From: Simon Davis
Sent: 07 January 2020 17:39
To: Planning Scanning
Subject: FW: Inglenook P/58/19/PL

From: Richard Dollamore [REDACTED]
Sent: 07 January 2020 14:36
To: Simon Davis [REDACTED]
Cc: 'Gareth Giles | Whaleback' [REDACTED]
[REDACTED]
Subject: RE: Inglenook P/58/19/PL

Visibility Splays and Internal Swept Path Analysis

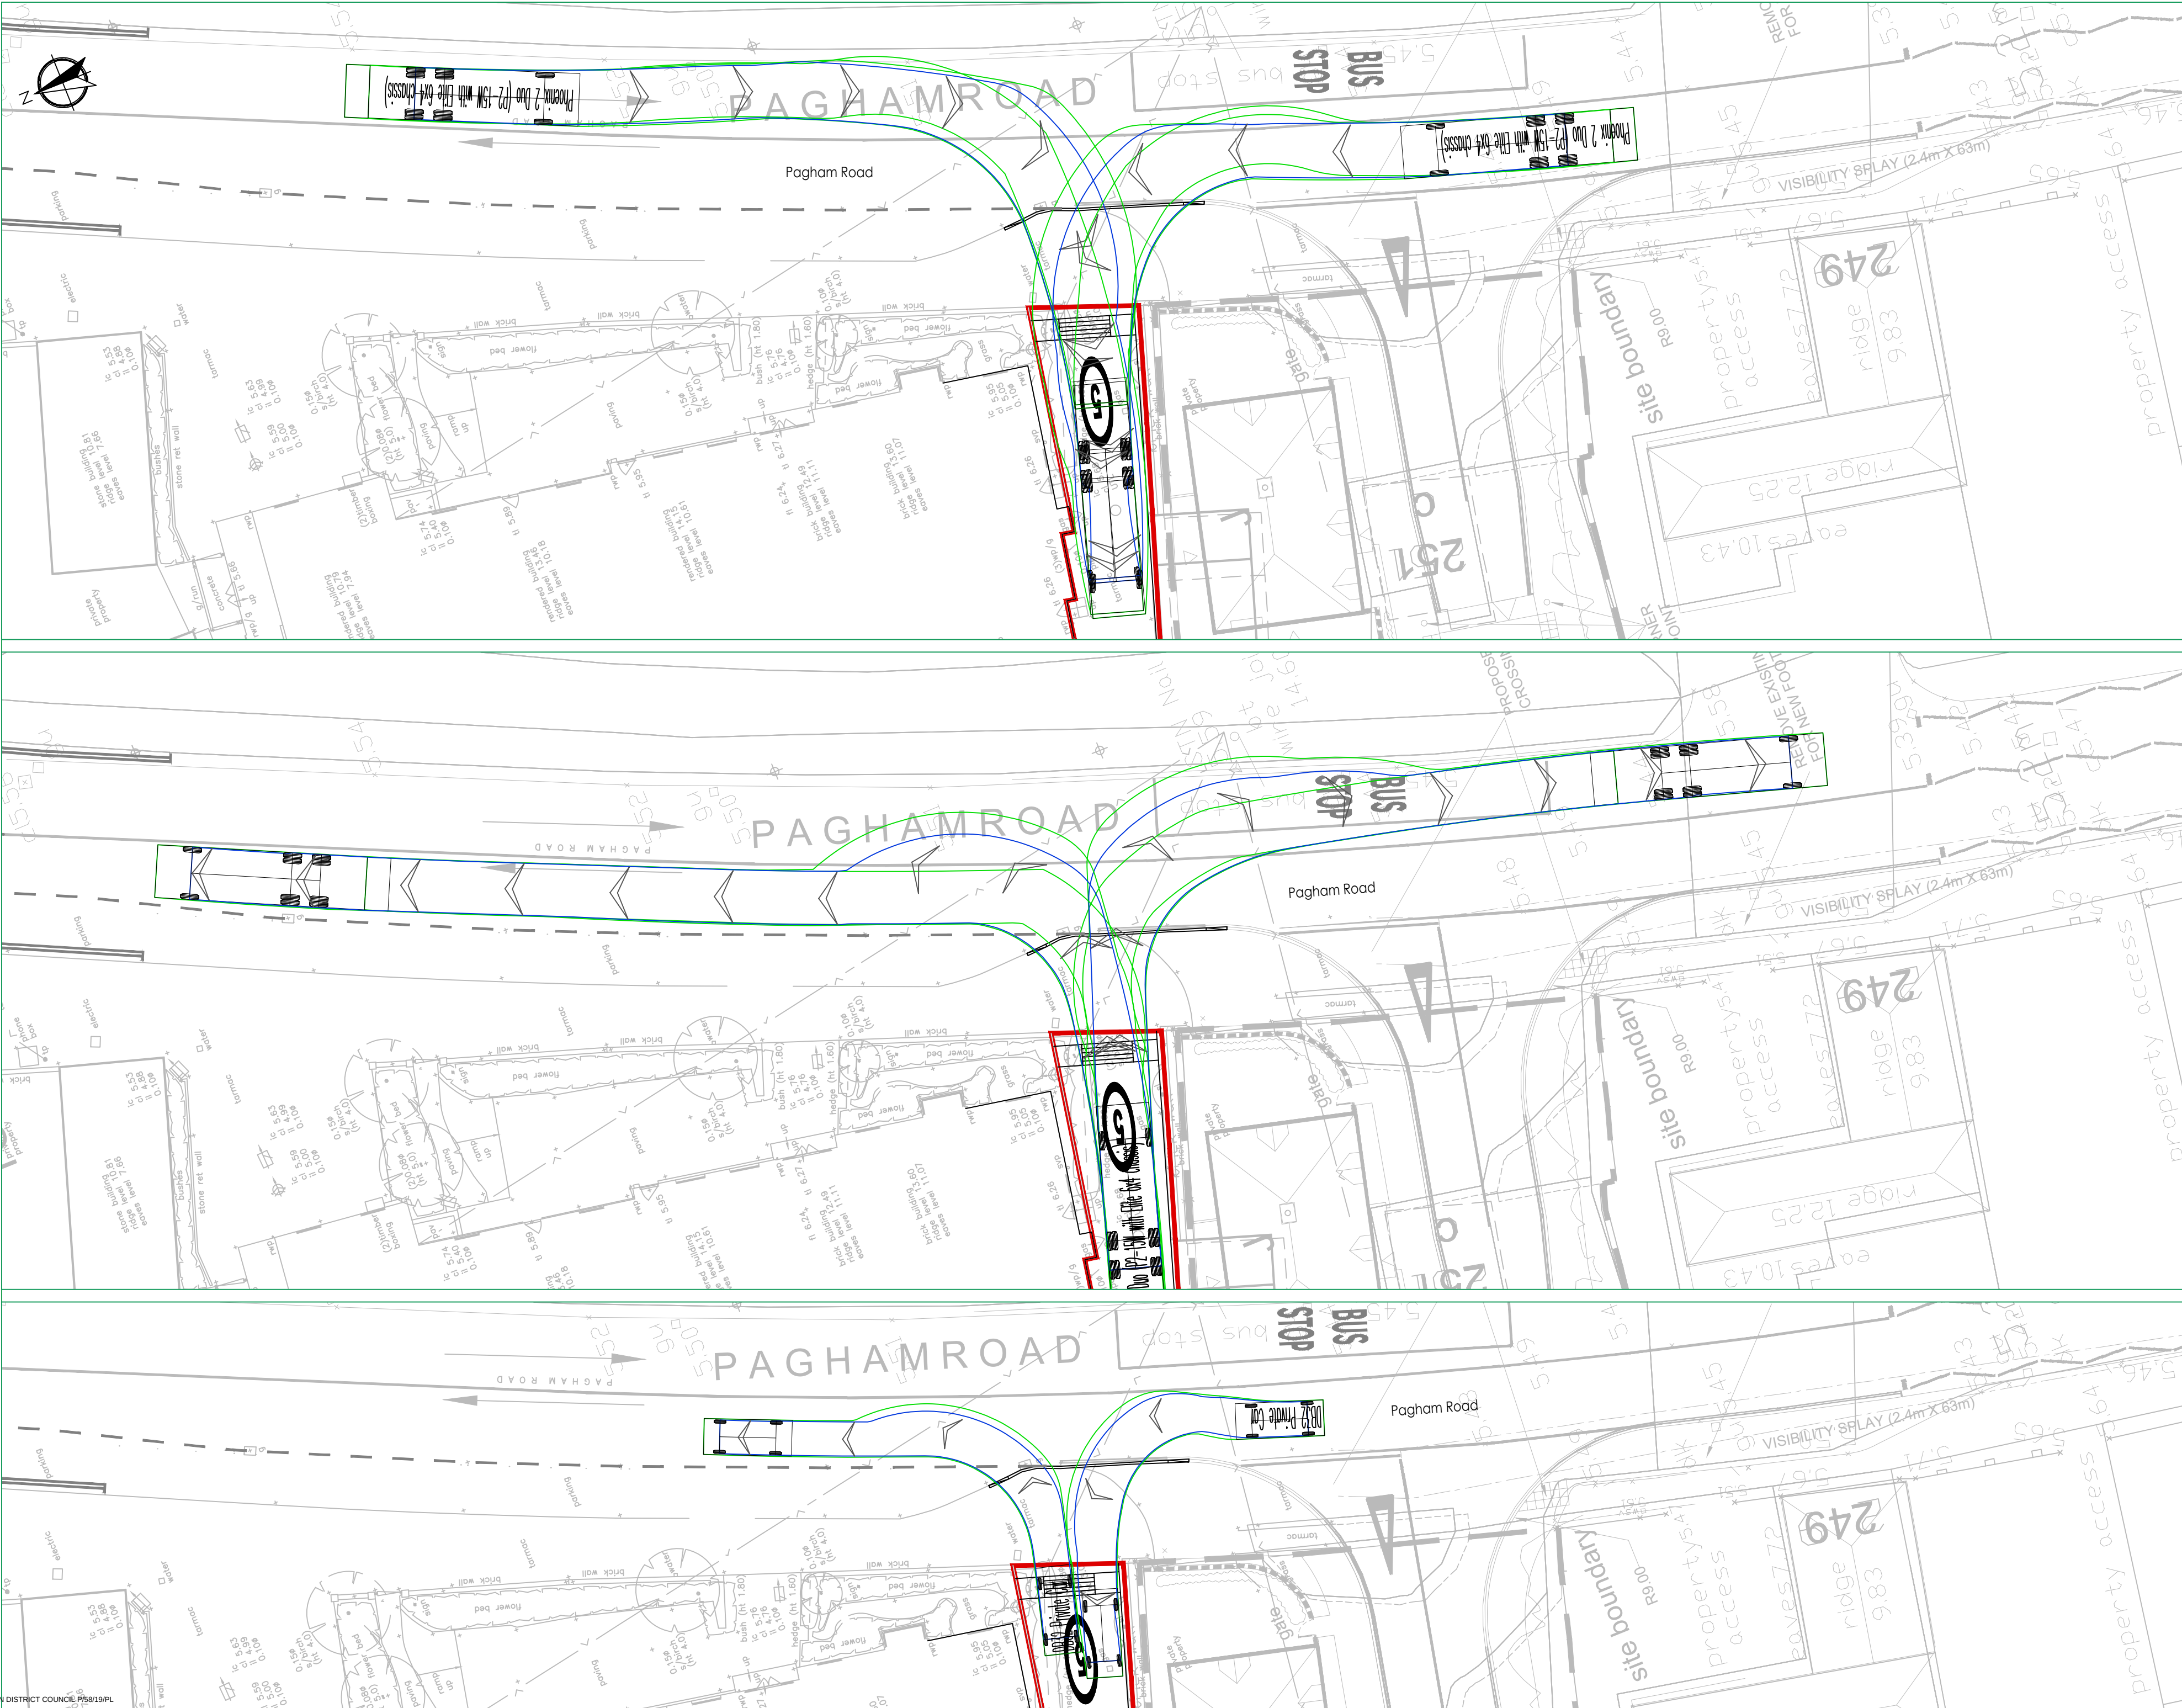
2. In 5.1.2 the report refers to Manual for Streets 2 with regards to visibility splays. However, MfS2 states that 'It has often been assumed that failure to provide visibility at priority junctions in accordance with the values recommended by MfS1 will result in an increased risk of injury collisions. Research carried out by TMS Consultancy for MfS2 has found no evidence of this.' Section 10.5 of MfS2 discusses the measurement of X and Y distances and concludes that: 'based on the research referred to above, unless there is local evidence to the contrary, a reduction in visibility below recommended levels will not necessarily lead to a significant problem.' Vehicle speeds along this stretch of Pagham Road are low, with any parking on the east side also causing vehicles to slow down further.
